Markup Summary

Cursory redlines Steve Kuehster 9/25/2019

C2.01
Sheet 3 of 38

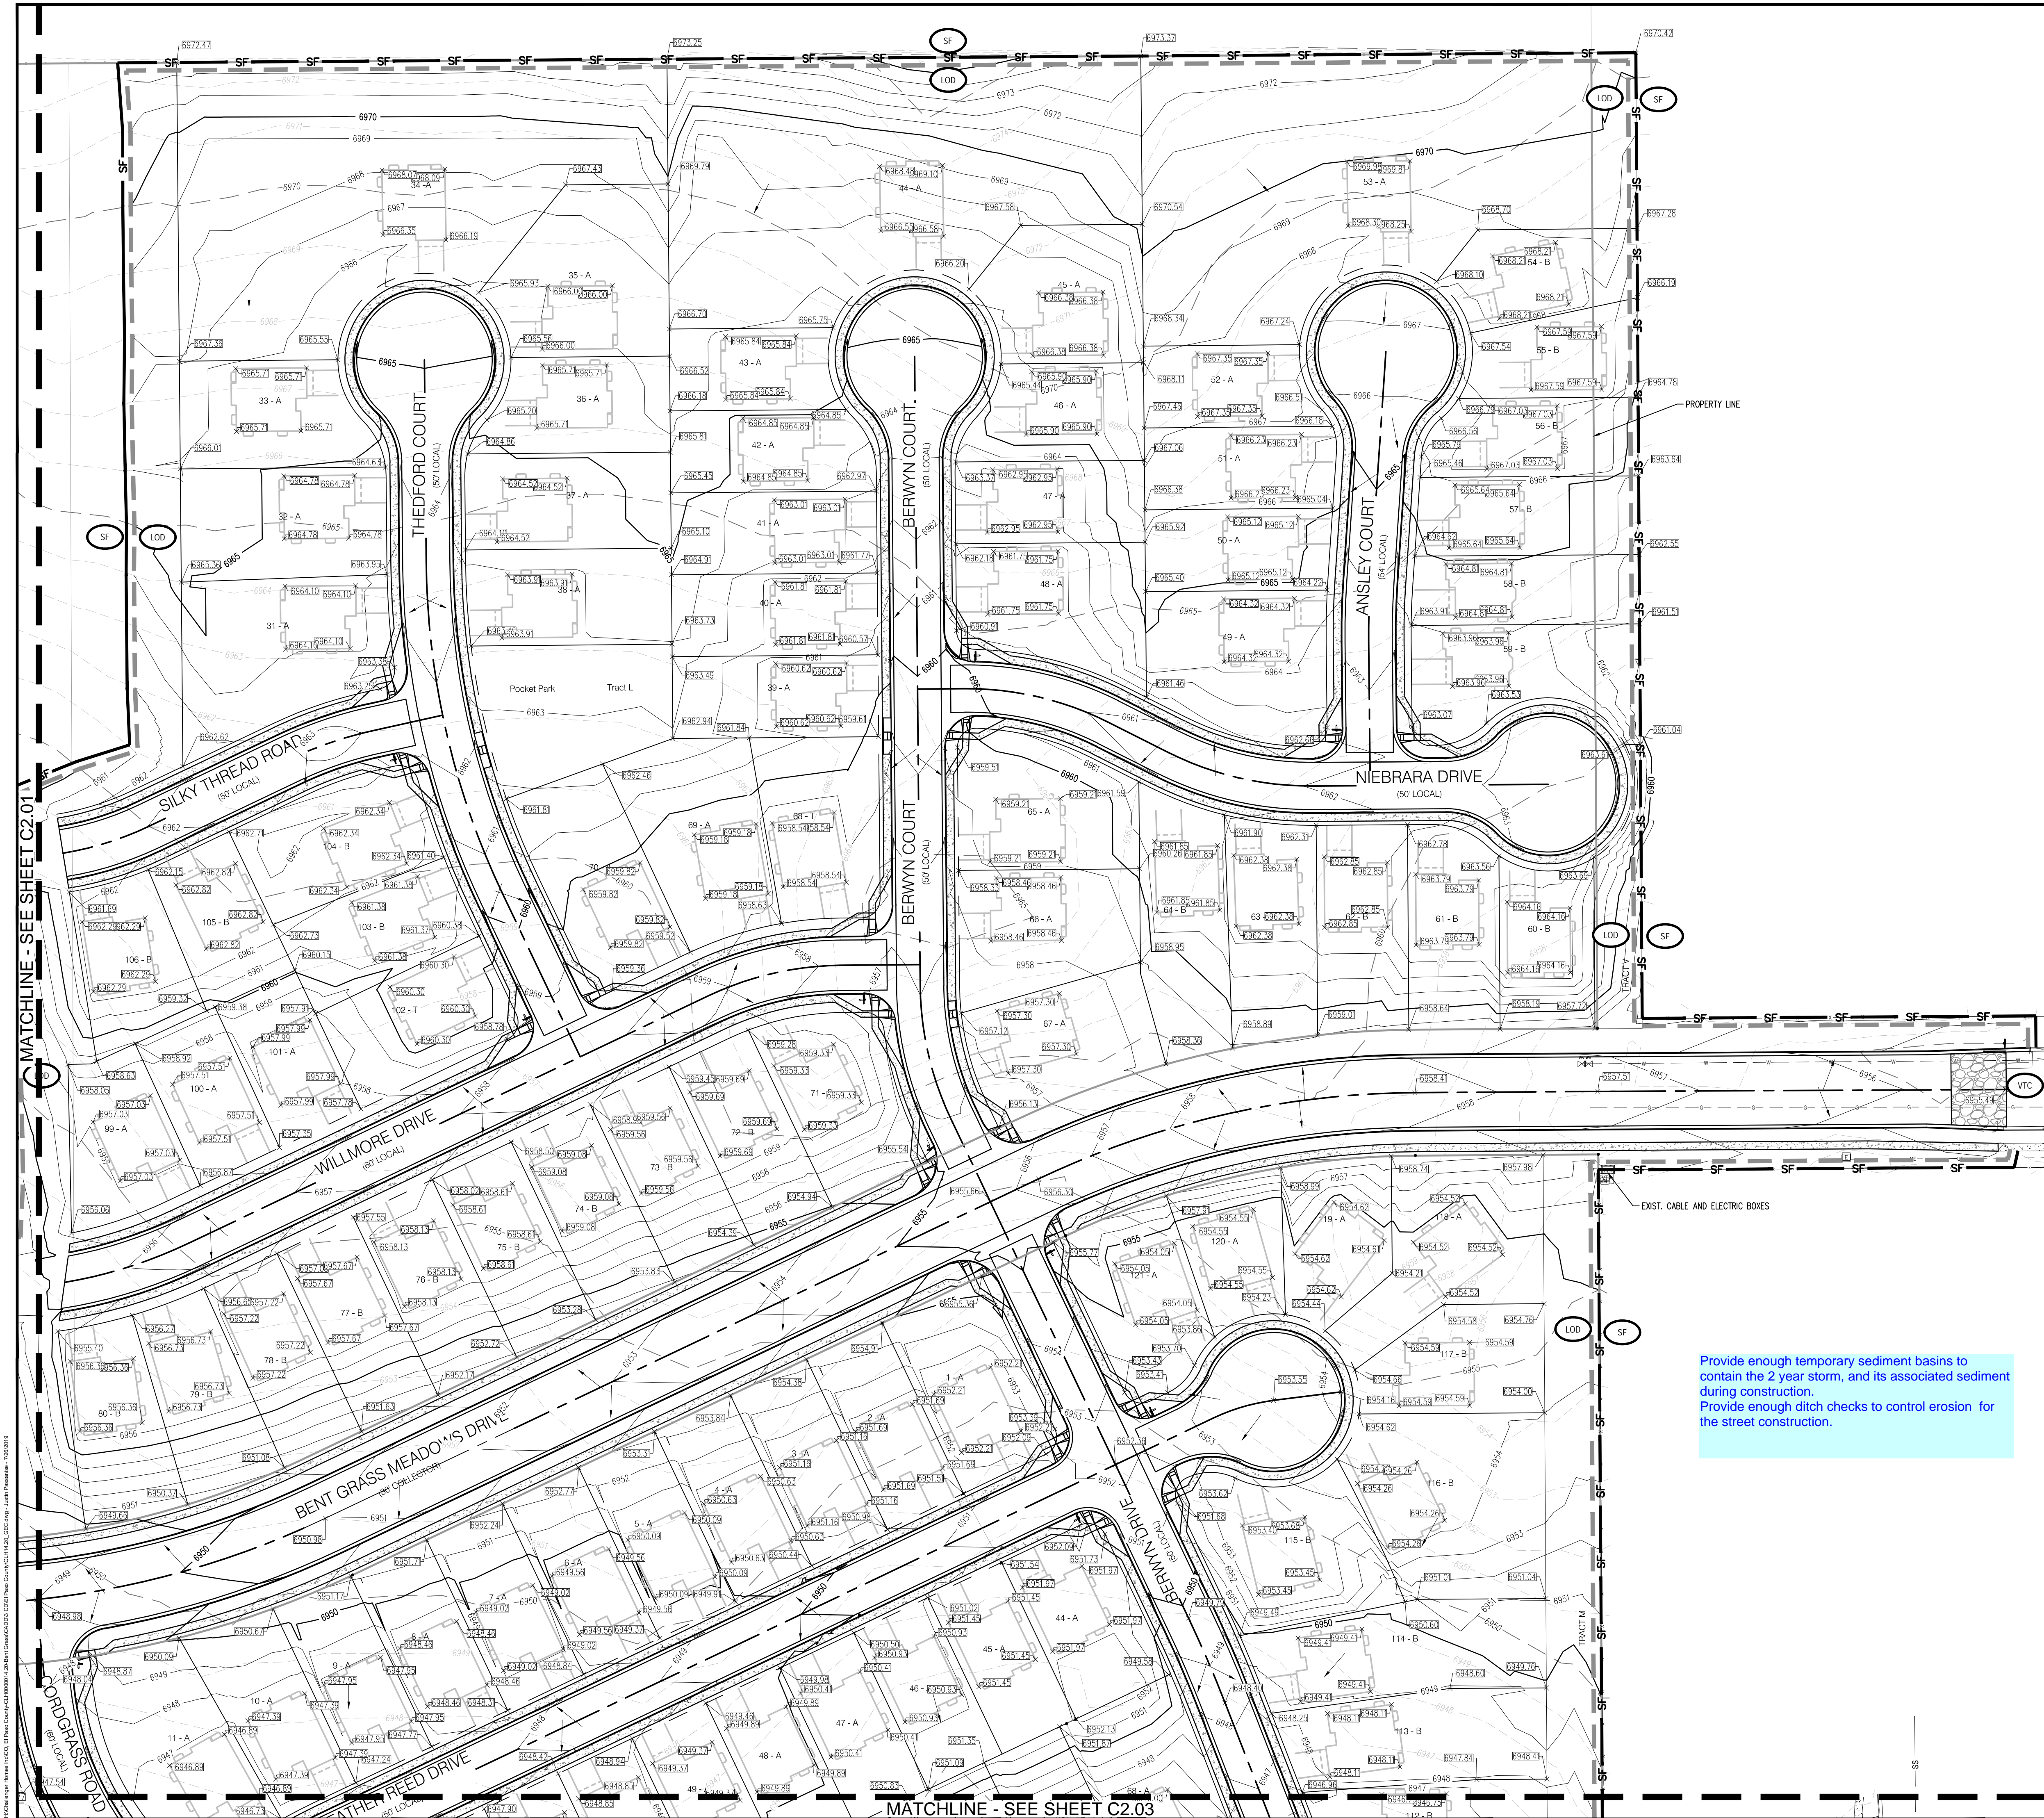
Provide a vertical curve

Provide a vertical curve

Provide centerline curve

Provide centerline curve

Intersection angle doesn't meet criteria

Intersection angle doesn't meet criteria

Intersection angle doesn't meet criteria
